May 10, 2019

**Re: McDonalds - 8315 Montgomery Blvd NE
Tract A-1-F of the Los Pastores Shopping Center
Grading and Drainage Plan - Engineer's Stamp date 4/4/2019 (F19D013A)**

Based on the application received 5/9/2019, the above referenced plan cannot be approved for building permit until the following comments are addressed.

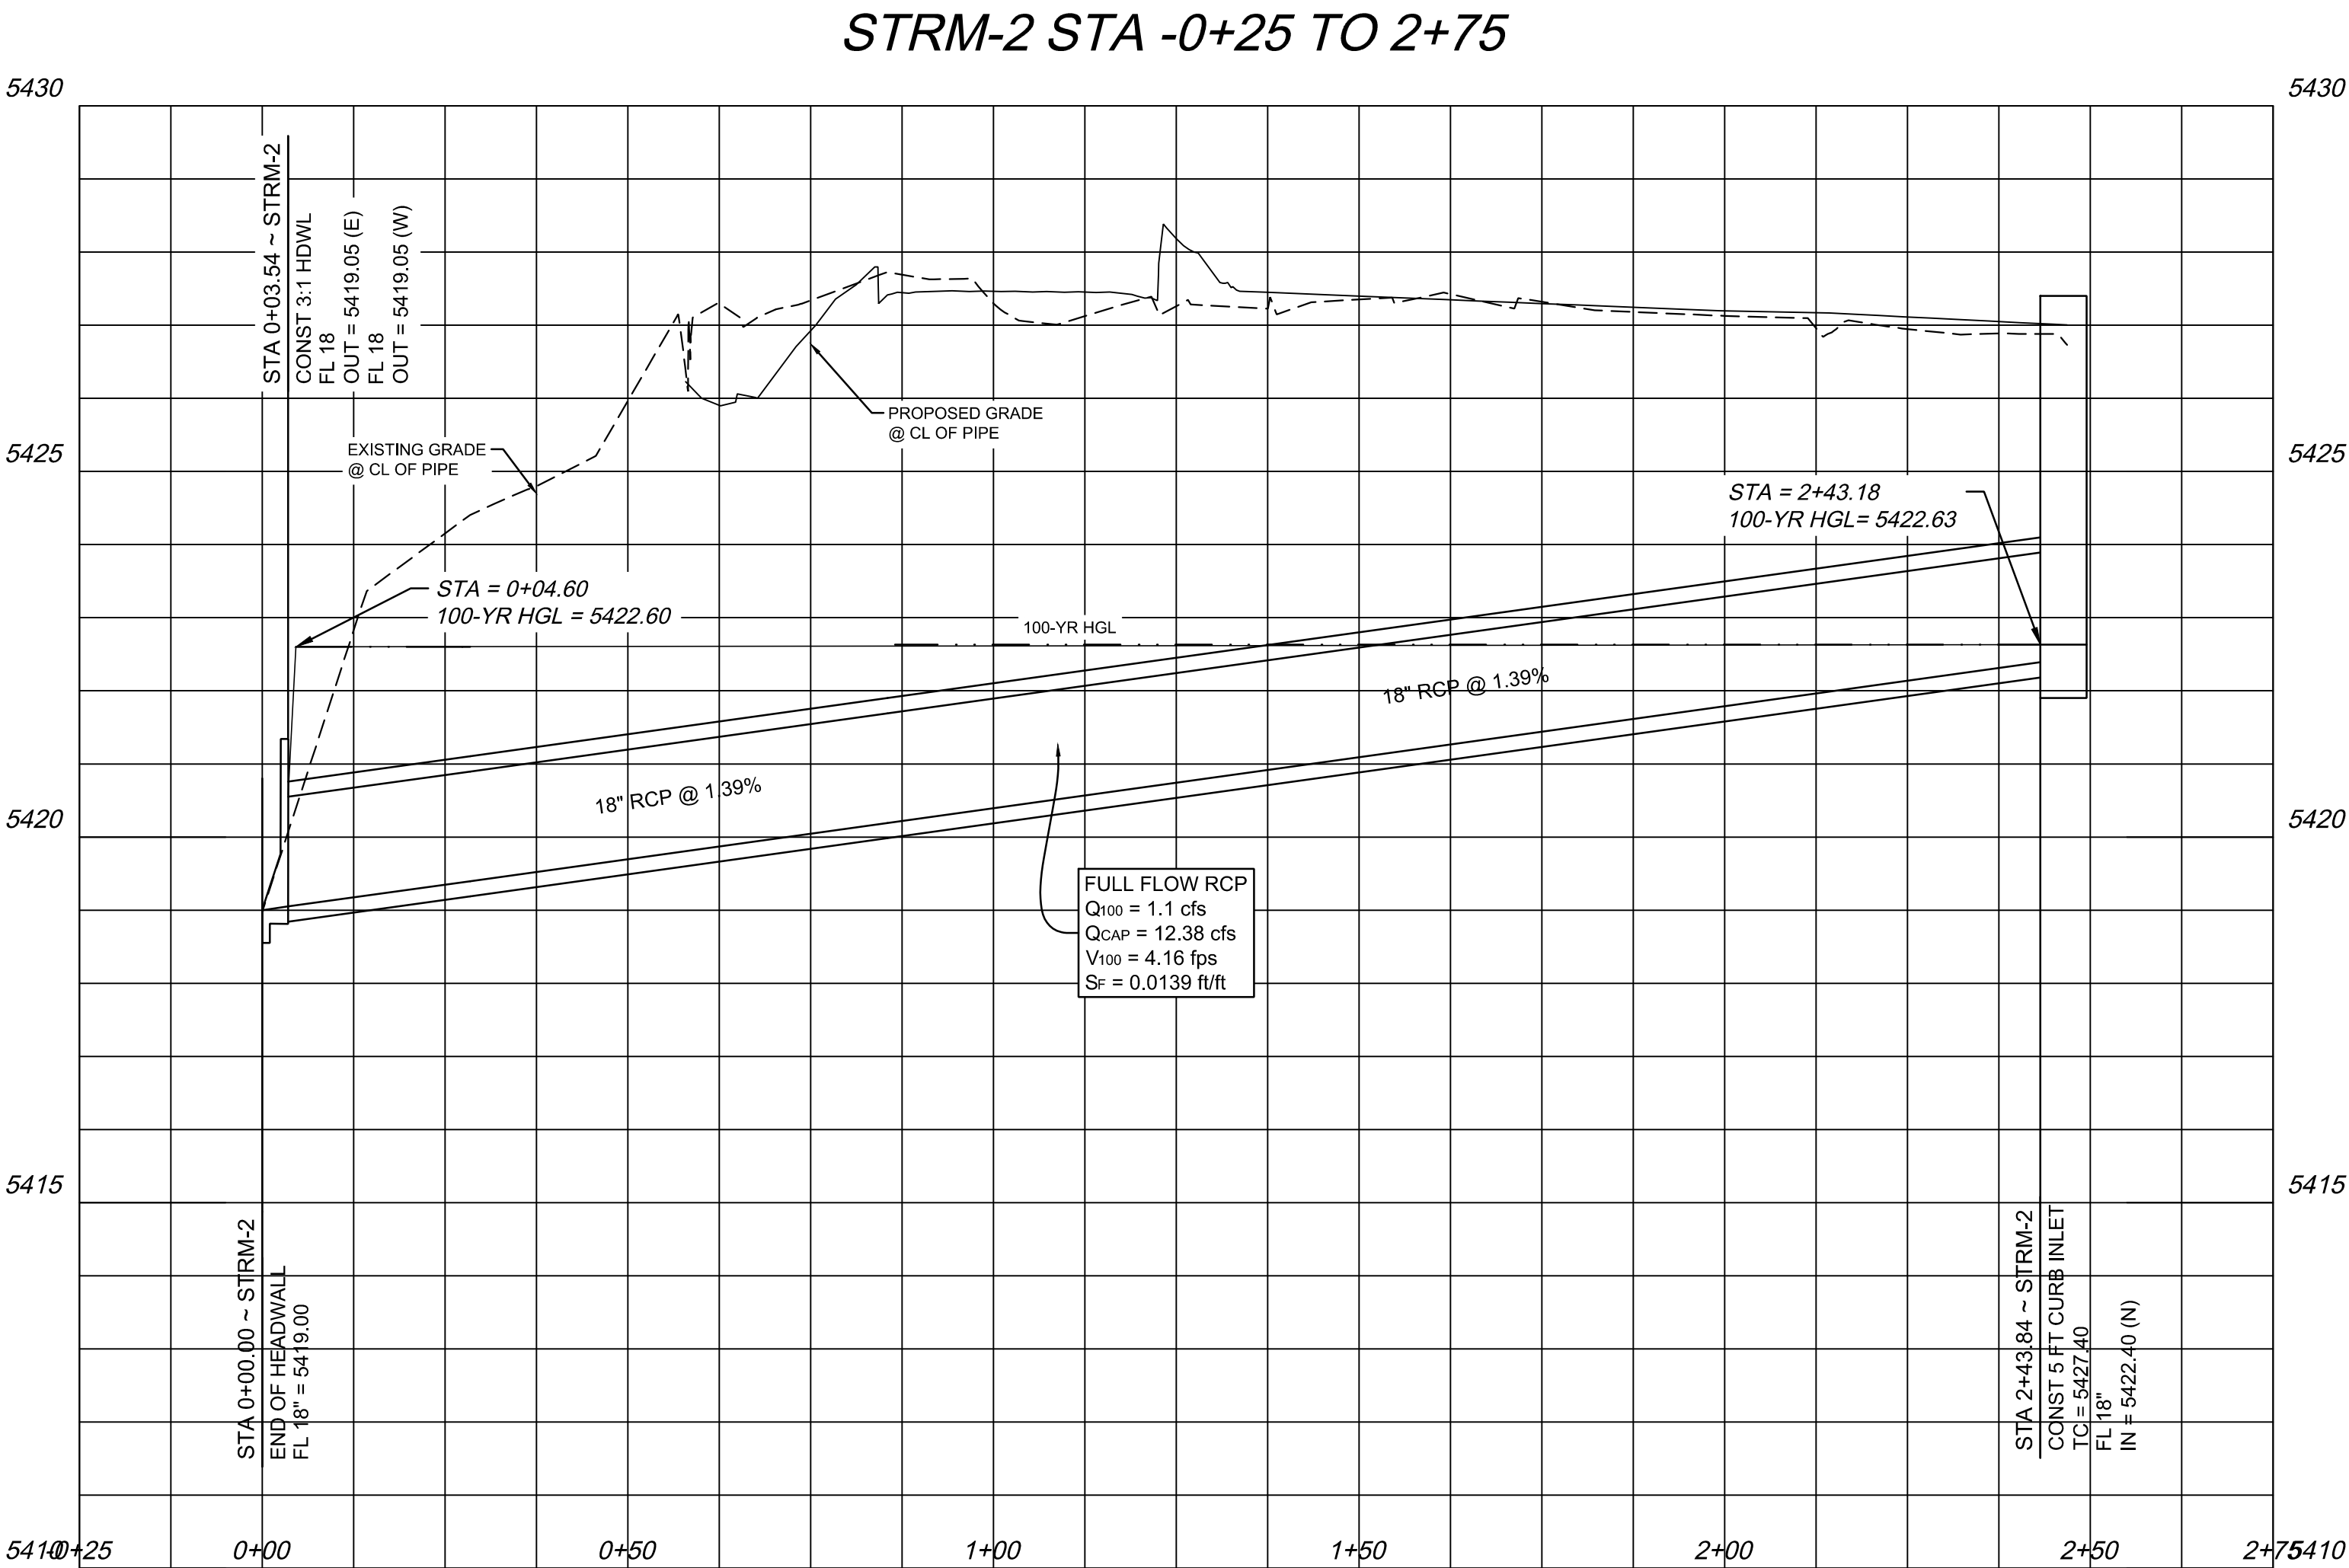
5. Ponds #1 and #4 appear to have been deleted from the plan, Sheet C8.1 or are not labeled. If so, please delete the Stage Storage Volume table from sheet C8.2 for those two ponds. Also delete them from the "Pond FF Elevation Table" on that sheet. The second table titled "First Flush Volume Calculations" should look more like the one below using the volumes from the "Stage Storage Volume" tables.
